Department of Primary Industries

OUT16/45946

Martins Creek Quarry (SSD 6612) Comment on the Environmental Impact Statement

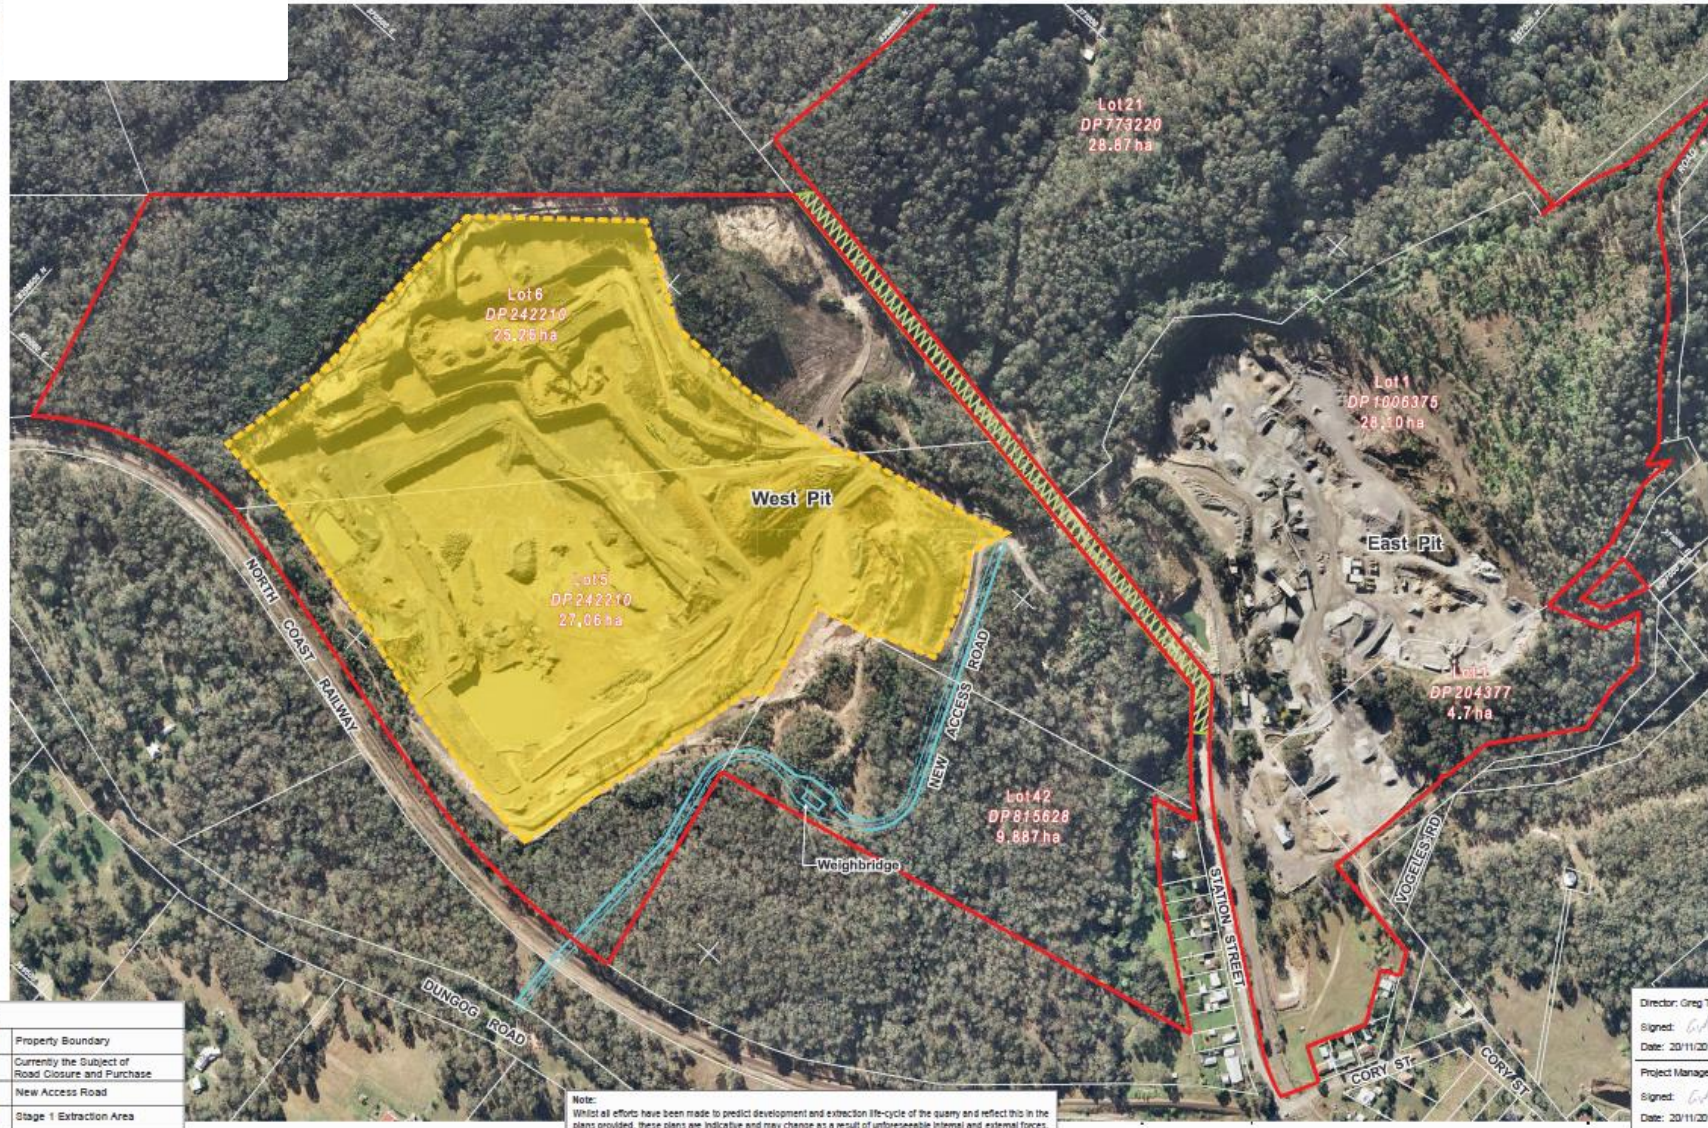
- The road extending north from Station Street, Martins Creek must be closed and acquired by the Proponent prior to the Proponent undertaking any works on this land.
